6th June 2017

Re—R/91/17/PL Erection of 2 No Dwellings & Garages—The Spires

JOB NO. 1438 DRAWING NO 01 © 6th MARCH 2017

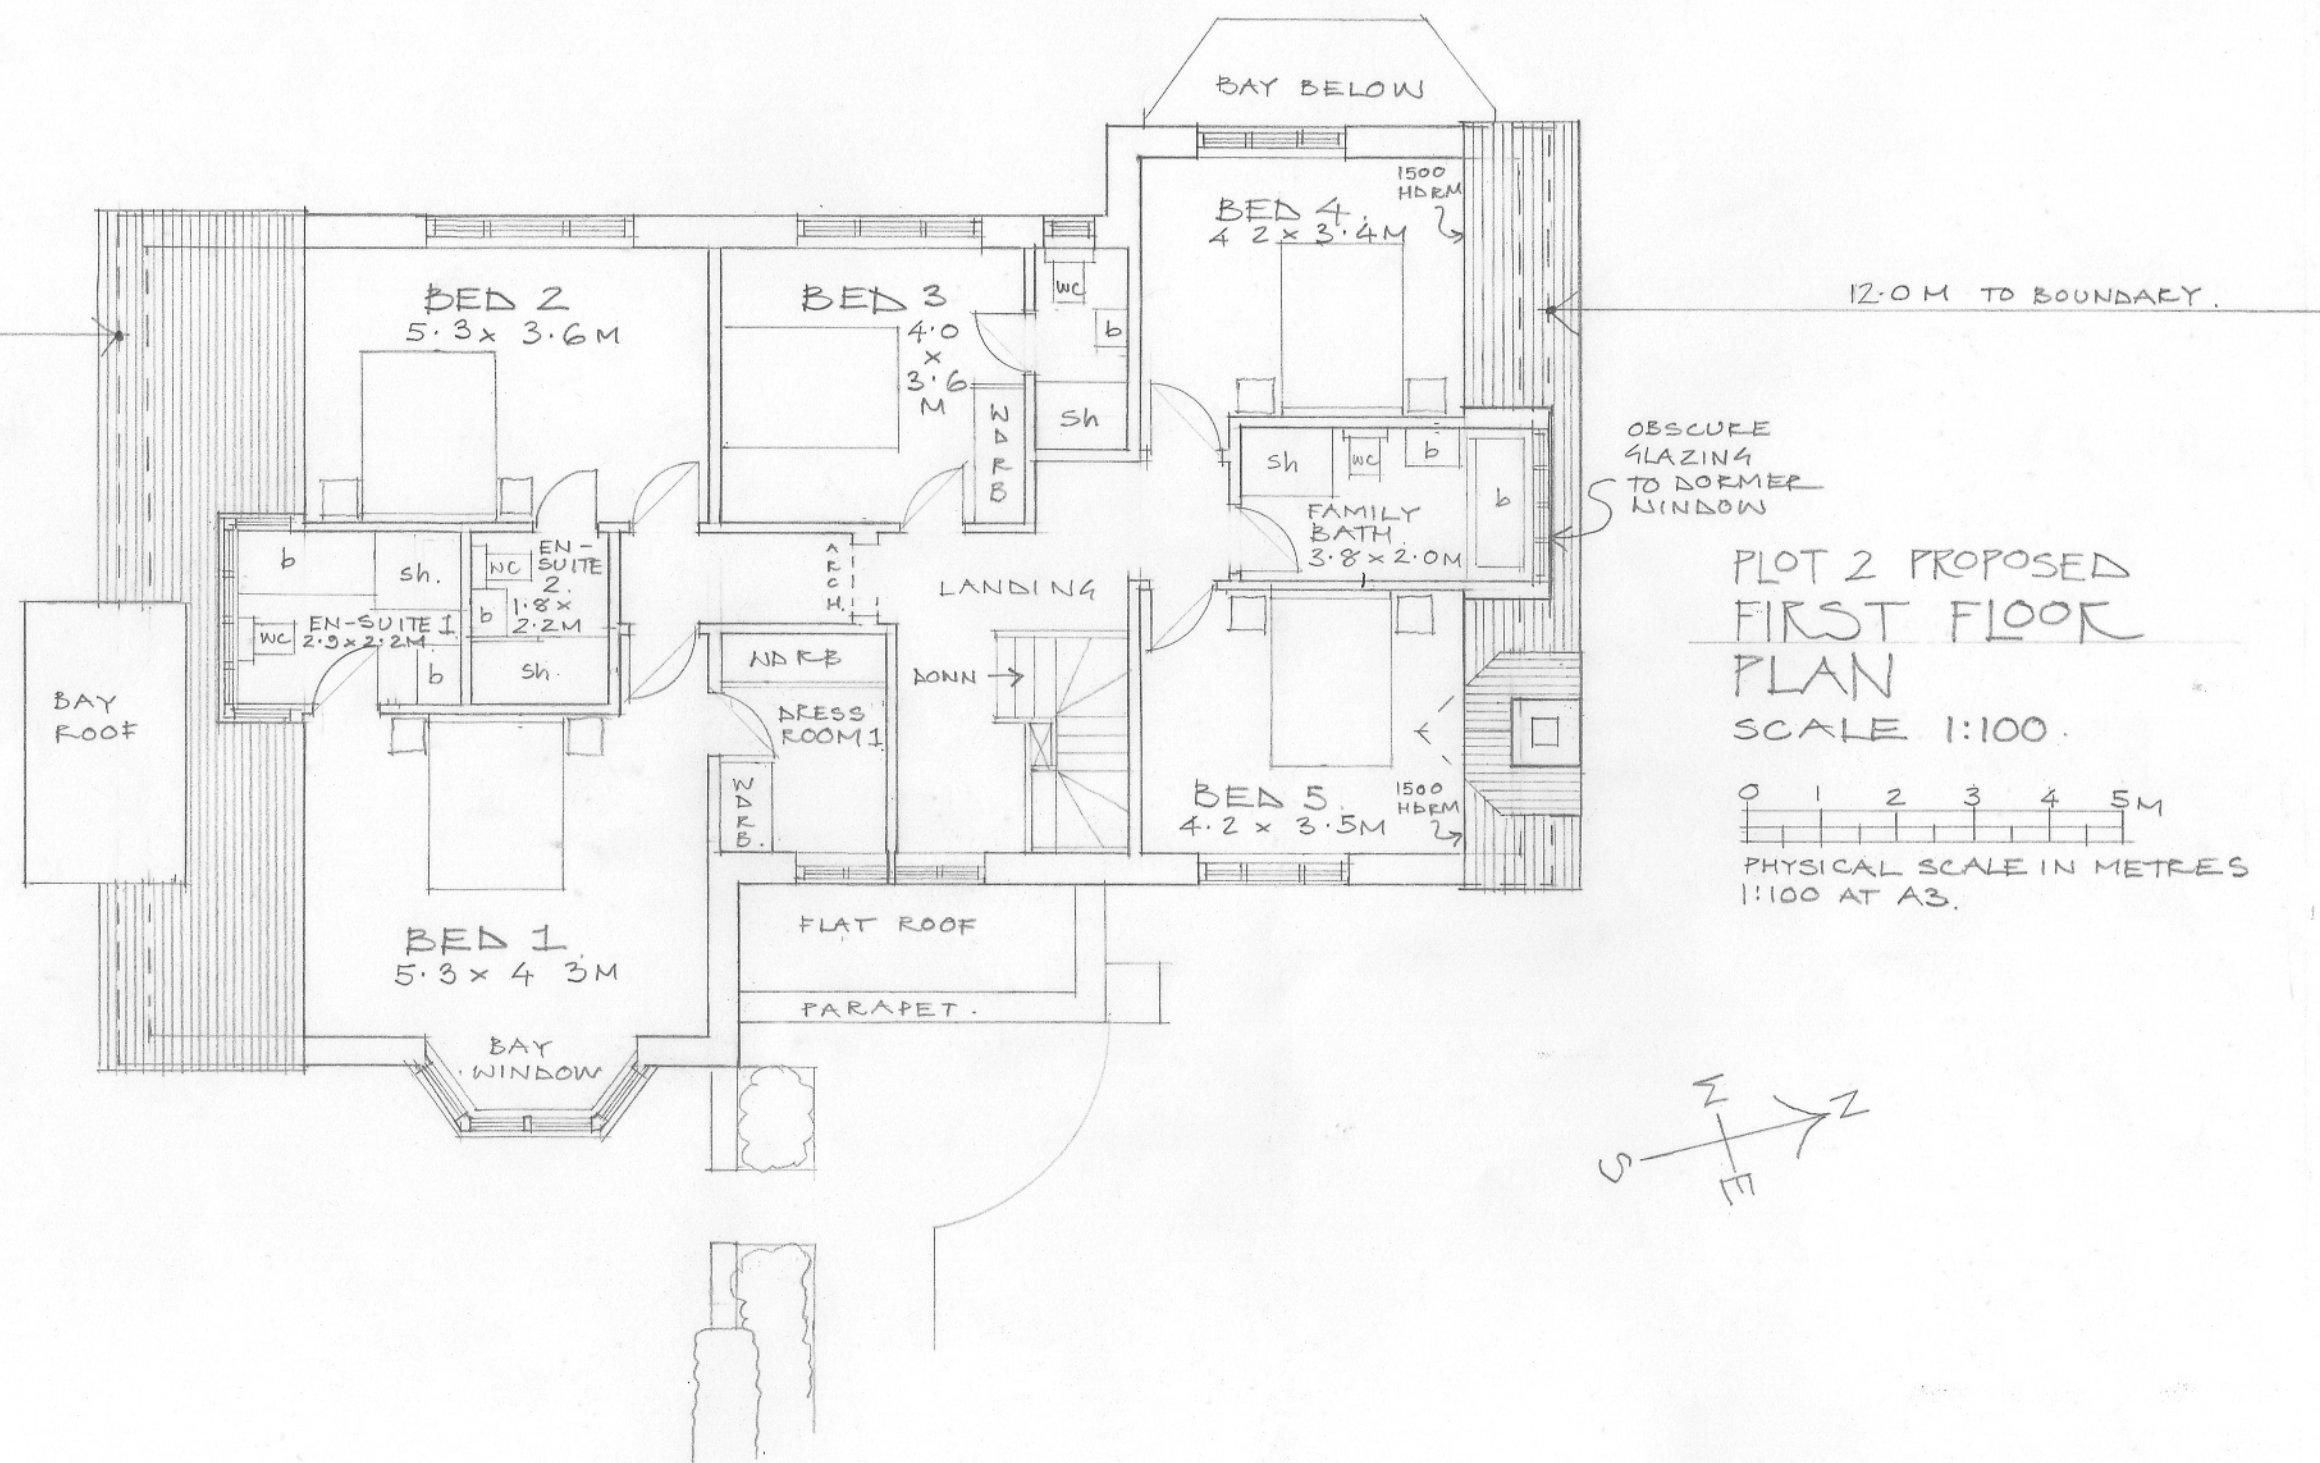
With regard to the above planning application I write with concern to the close proximity of one of the proposed property's to the boundary with my property of No 1 Cross Road.

The distance as shown on the plans for the development is not equal to the distance from the Spires property, I would therefore request that serious consideration be made to move the property further south by at least 4 metres therefore giving a greater distance from my boundary.
